WEST SUSSEX COUNTY COUNCIL CONSULTATION

TO:	Arun District Council FAO: Simon Davis
FROM:	WSCC - Highways Authority
DATE:	27 April 2020
LOCATION:	The Beach Hotel, former Mud Club & 2-4 Waterloo Square Bognor Regis PO21 1SU
SUBJECT:	BR/282/19 Redevelopment into 35 No. 1 & 2 bed apartments and 3 No. commercial units (A1 Retail or A3 Restaurant/Cafe). This application affects the character & appearance of The Steyne, Bognor Regis Conservation Area & may affect the setting of a listed building. More Info/ Amended Description/ Proposal
DATE OF SITE VISIT:	29 March 2020
RECOMMENDATION:	More Information

Project Title:	Date:
Waterloo Square, Bognor Regis	20.04.01
Document Title:	Drawn by / Checked by:
Proposed Ground Floor plan	SR / GG
Drawing Scale / Sheet Size:	Client:
1:200 @ A3	B5 ltd
Drawing Status:	Drawing Number / Revision:
PLANNING	18.103.402

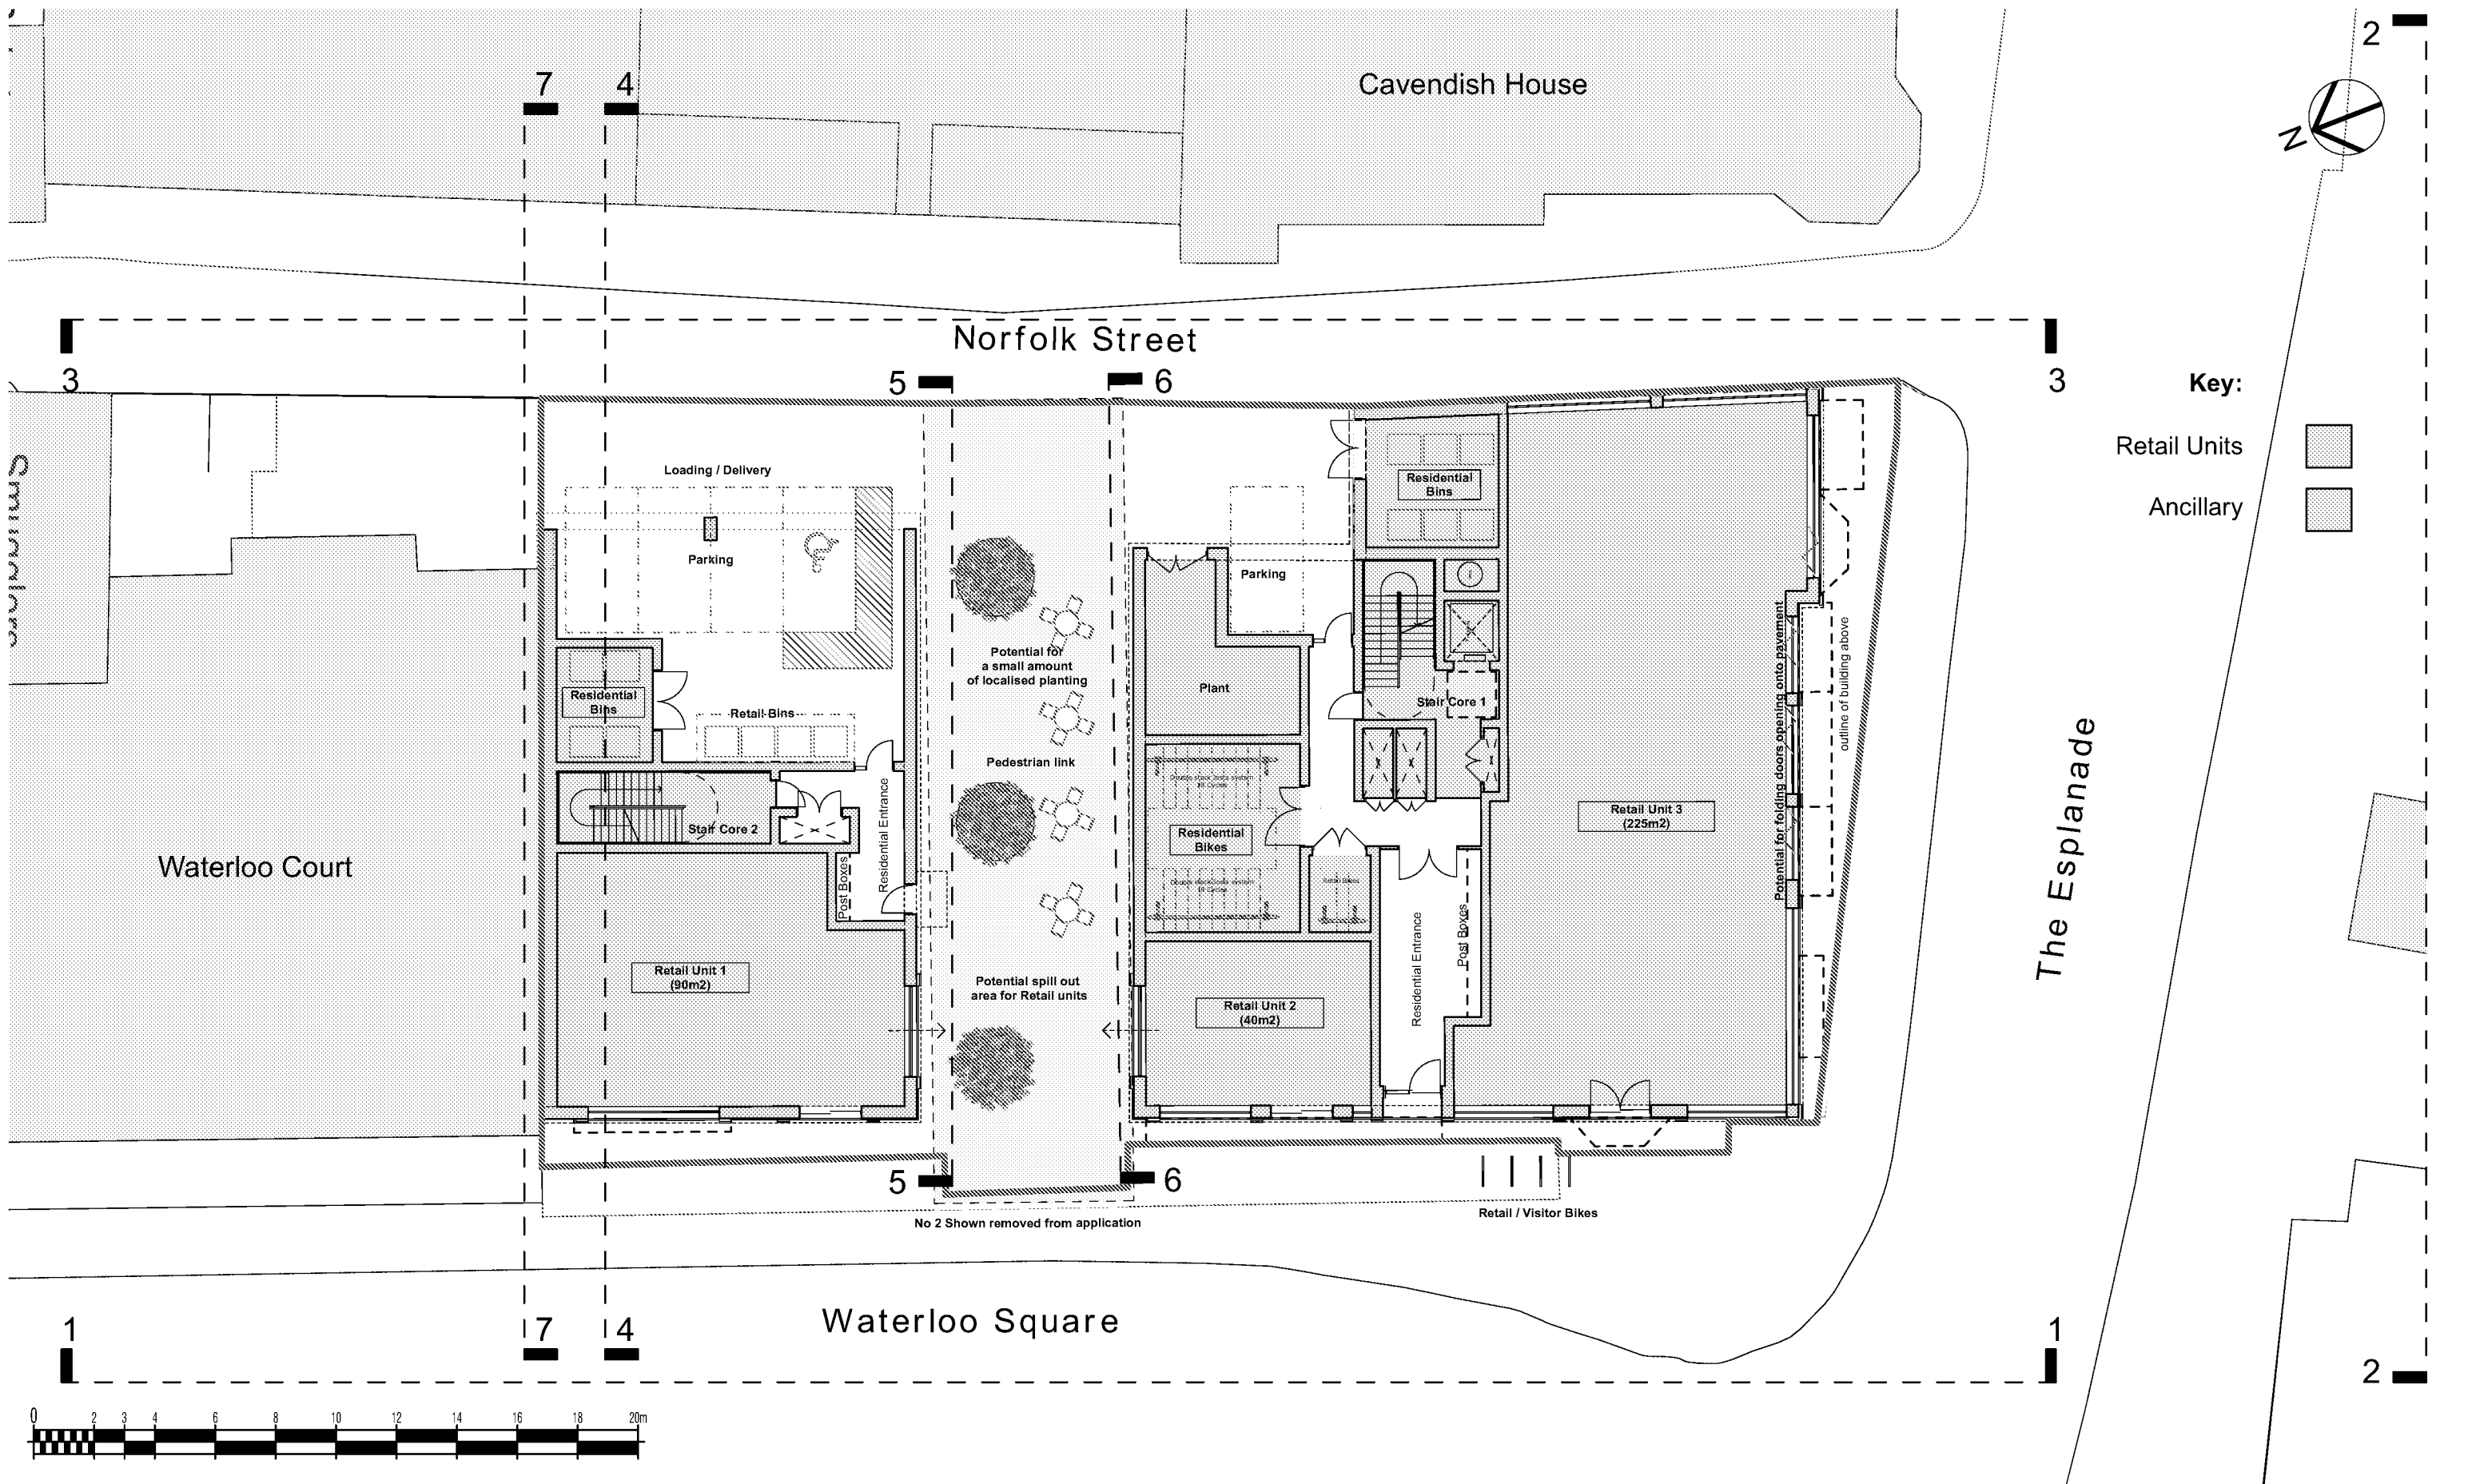
No vehicular access is now proposed from Waterloo Square. Some vehicular access to loading bay and limited car parking is proposed from Norfolk Street (one way) to the rear. Whilst no turn on site is proposed for the car parking, considering the low traffic levels and anticipated speeds, the LHA would not raise an objection to this, in principle. Nevertheless, the spaces and the revised loading bay should be demonstrated as workable via swept path tracking diagrams. This should also include demonstration that anticipated vehicles can negotiate High Street from its junction with West Street and enter and exit the site.

The floor plans indicate a total of 23 x 2-bedroom and 12 x 1-bedroom units. Residential parking of 5 x spaces will be available accessed from Norfolk Street. One of these spaces will be marked up for disabled use. It is advised that 20% of the spaces are also provided with Electric Vehicle (EV) charging infrastructure. The Arun Supplementary Planning Guidance (SPD) requires 1 x space per apartment and thus the parking provision is short by 30 x spaces. Nevertheless, the LHA acknowledge the accessible location in terms of options for sustainable transport and proximity to amenities meaning that a reliance on the private car would not wholly be necessary for all residents. Furthermore, the surrounding area is a Controlled Parking Zone (CPZ) and thus overspill parking nearby on-street is not anticipated to take place in locations that would be deemed detrimental to highway safety. The Local Planning Authority (LPA) may wish to assess the amount of parking proposed from an amenity aspect, as there is no guarantee that residents would be able to obtain permits to park nearby on-street within the CPZ.

Residential bicycle parking for 36 x cycles has been indicated. This is line with the SPD, which would require one space per unit. Some internal retail cycle storage is proposed and it is assumed that this is for staff. External spaces are proposed for customers along the Waterloo Square frontage. The applicant should be mindful of the SPD guidelines for bicycle storage whereby A1 retail use would require 1 space per 100sqm for staff and 1 space per 100sqm for customers and A3 café use would require 1 space per 4 staff and 1 space per 25sqm for customers. Details of bicycle parking can be secured via condition.

- Updated RSA to assess alterations to access arrangements including access to parking and loading bay arrangements.
- Swept path tracking diagrams to fully demonstrate workability of proposed parking spaces and loading bay including wider access from High Street/West Street for anticipated vehicles (refuse/ deliveries).
- Trip generation – amended assessment of the anticipated vehicular trip generation from both residential and commercial element.
